PLANNING AMENDMENT

Application No. H13/0711/95

HOUSE & GARAGE, PLOT 3,
OFF ROMAN ROAD, MOULTON CHAPEL

**RESERVED MATTERS APPLICATION H13/0711/95 - HOUSE & GARAGE
PLOT 3, OFF ROMAN ROAD, MOULTON CHAPEL - DGM PROPERTIES LTD.**

PLOT 3

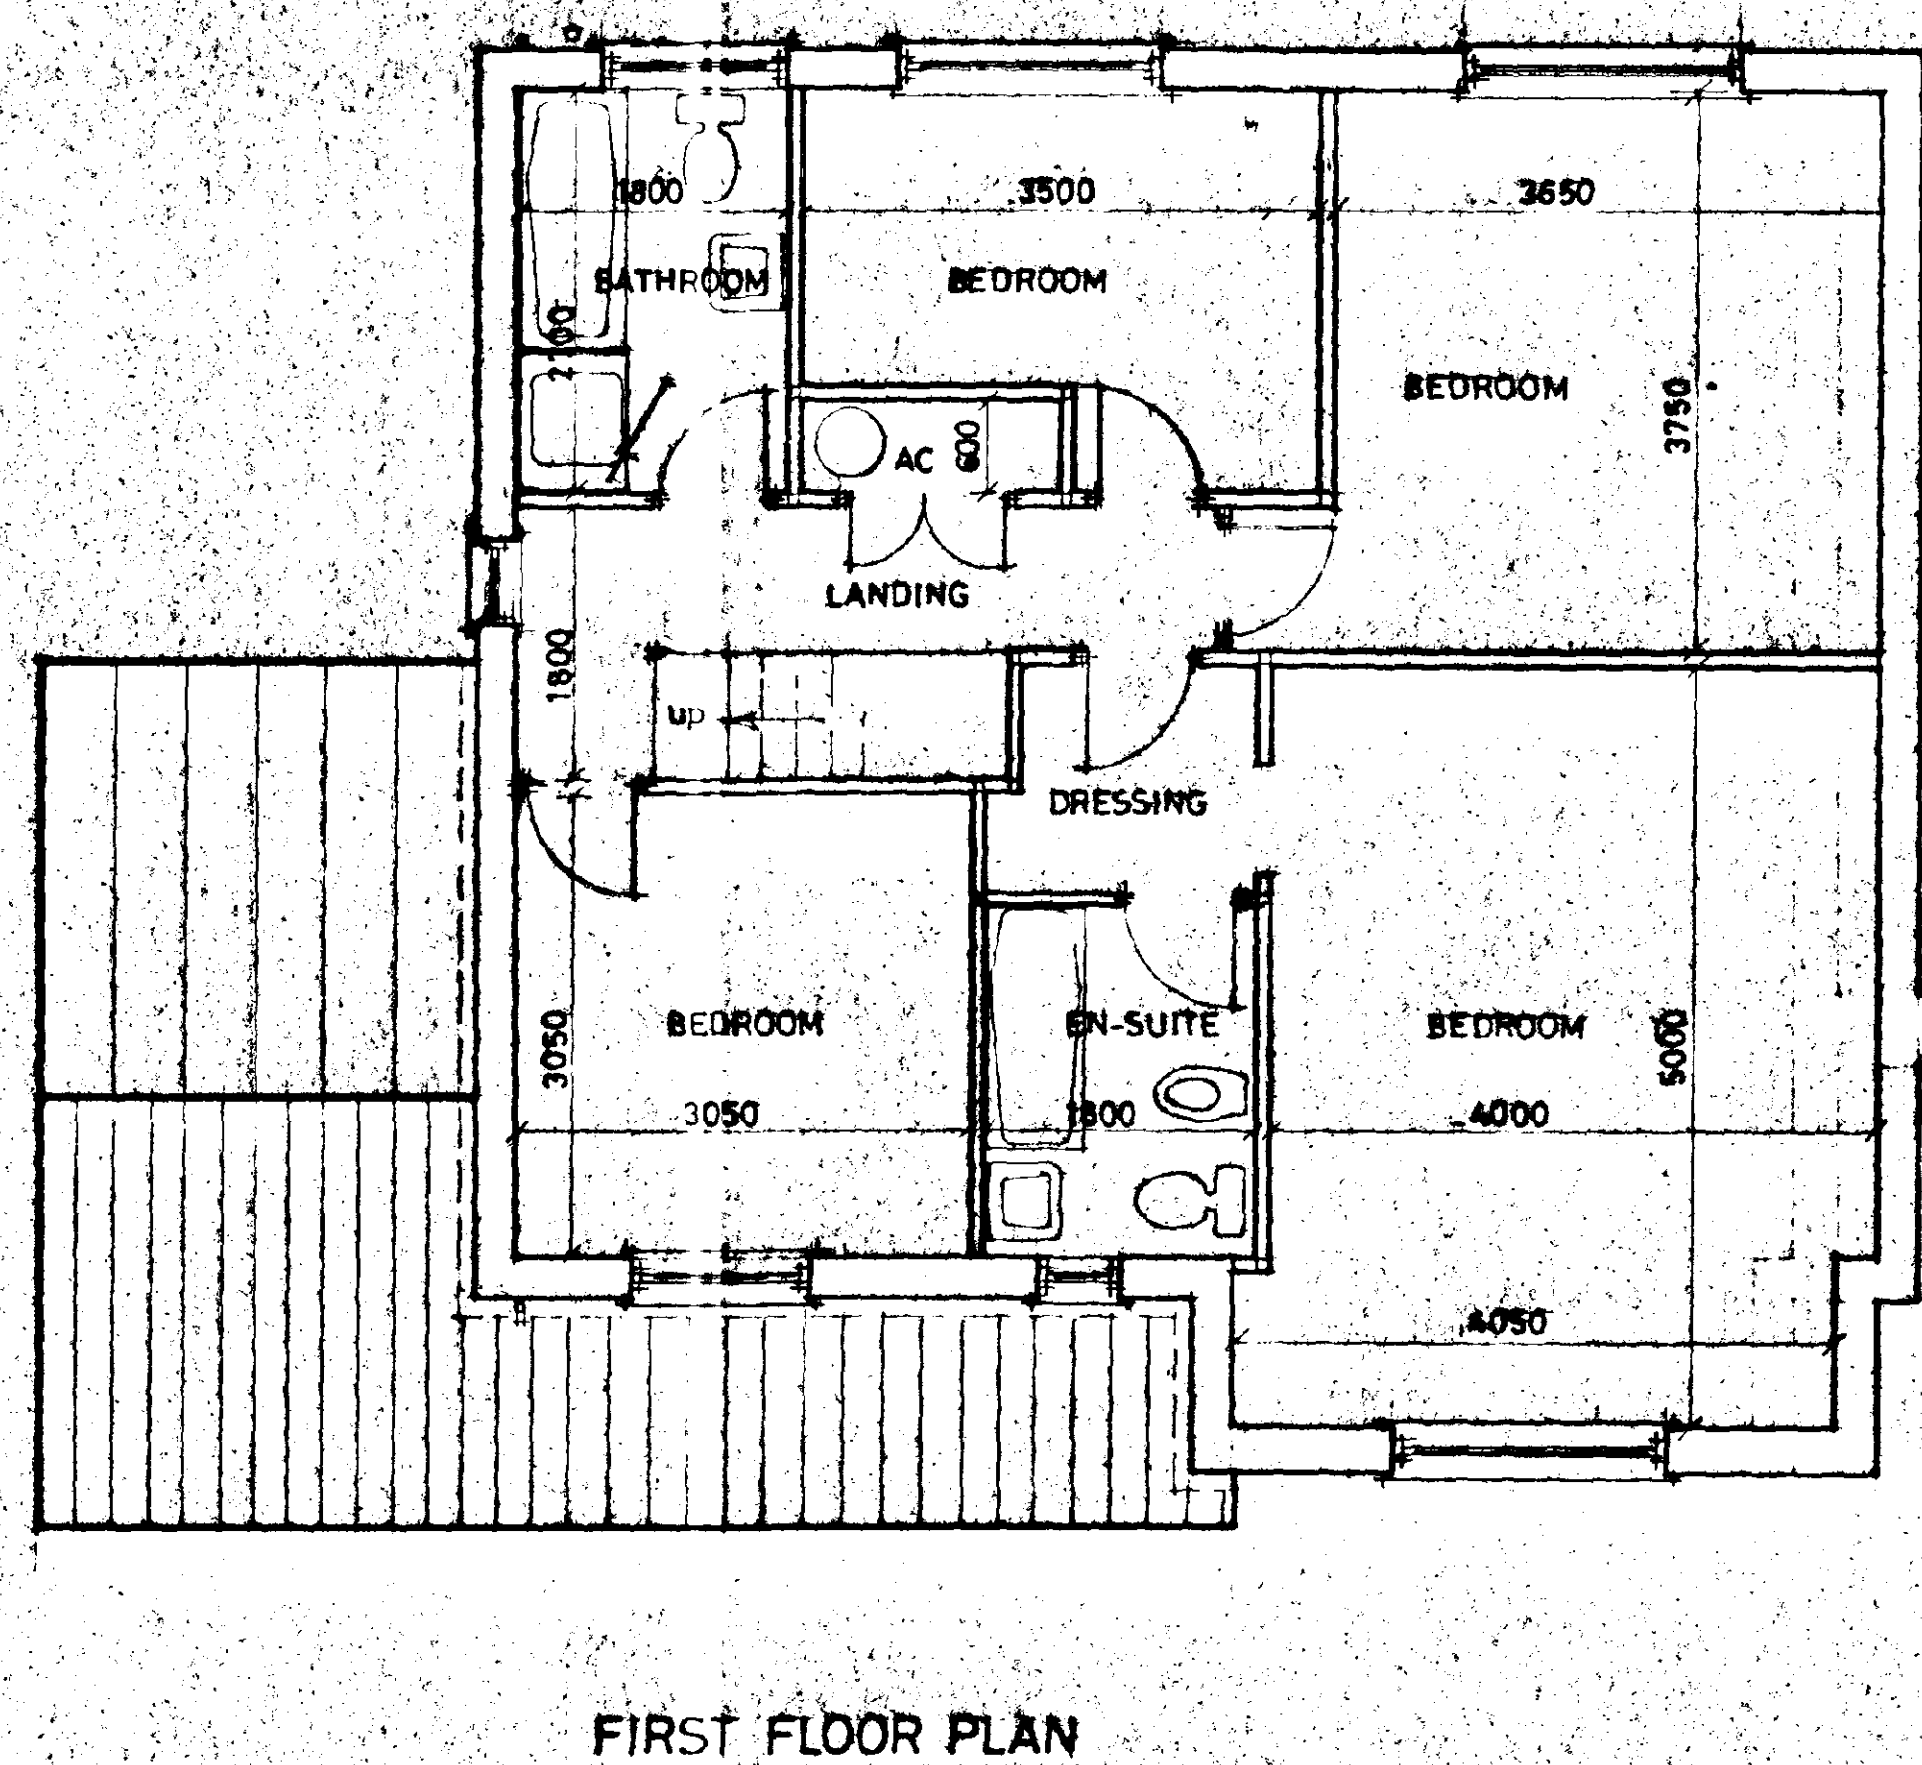
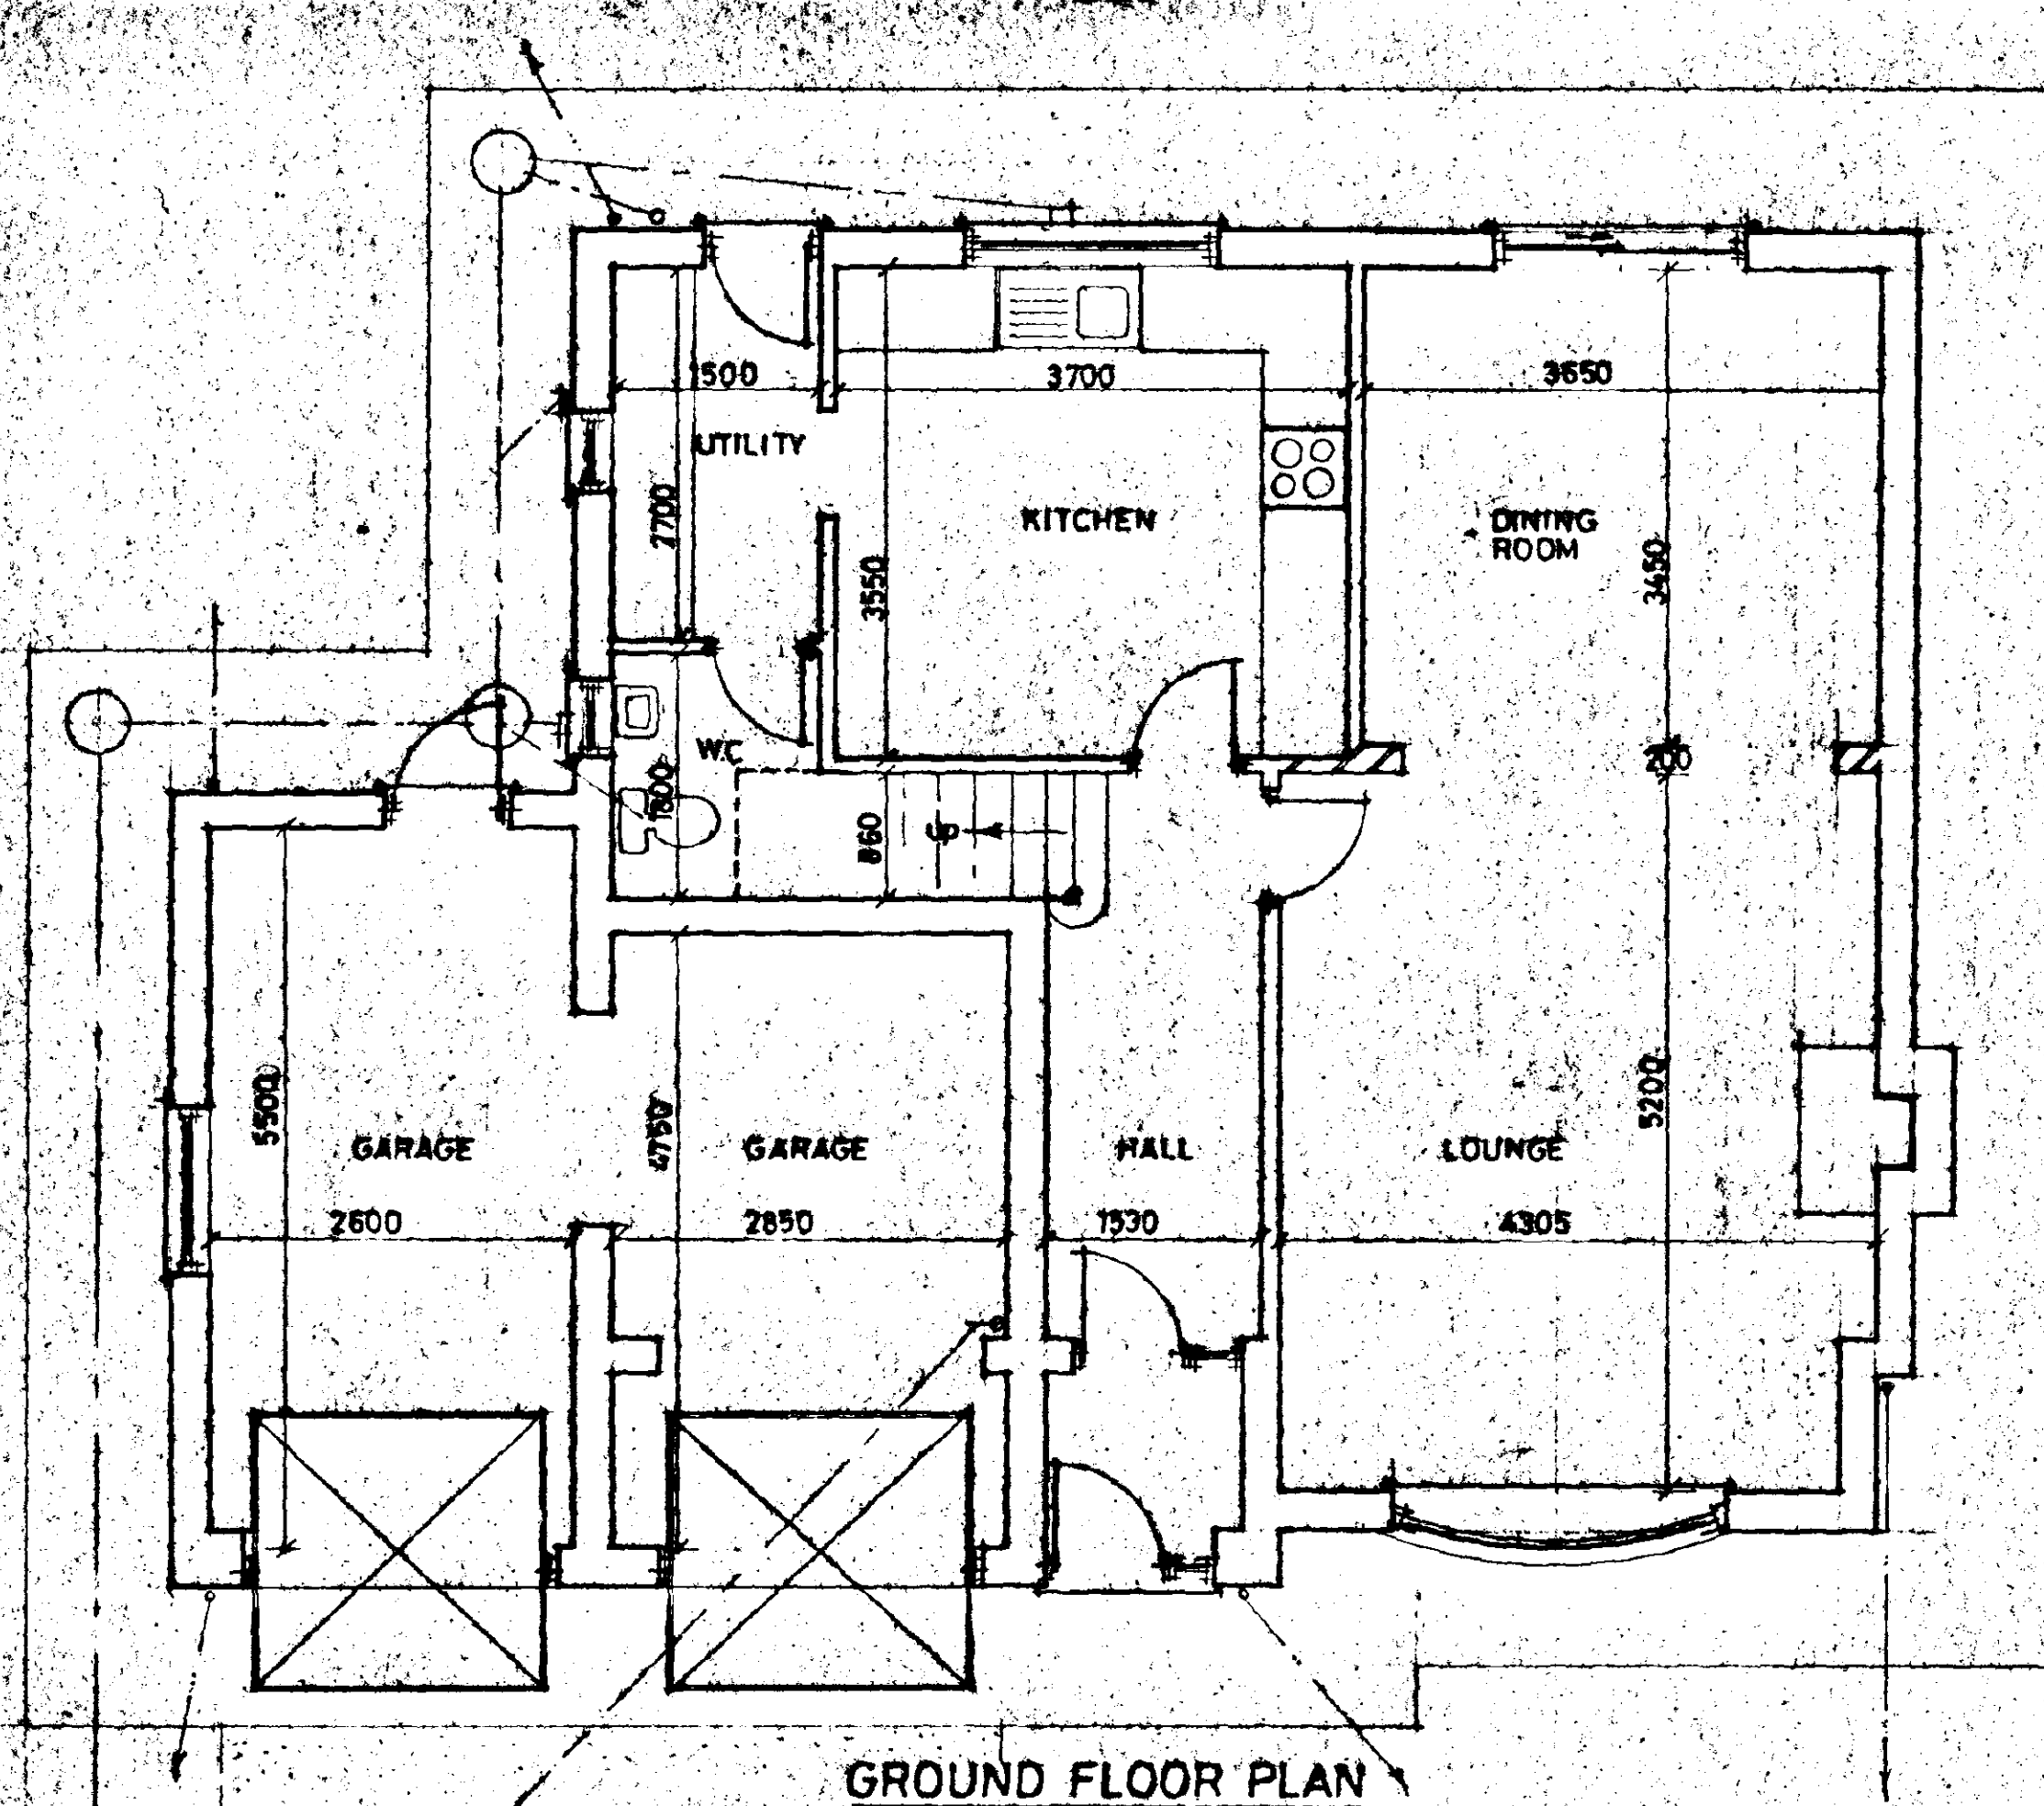
1. SOLDIER BRICKWORK ABOVE & BELOW WINDOWS
2. VERTICAL TIMBER GARAGE DOORS.
3. ADDITIONAL TREE PLANTING.

It is proposed to introduce soldier bricks above and below windows, to match Plots 1 & 2 and vertical timber boarded garage doors are to be used.
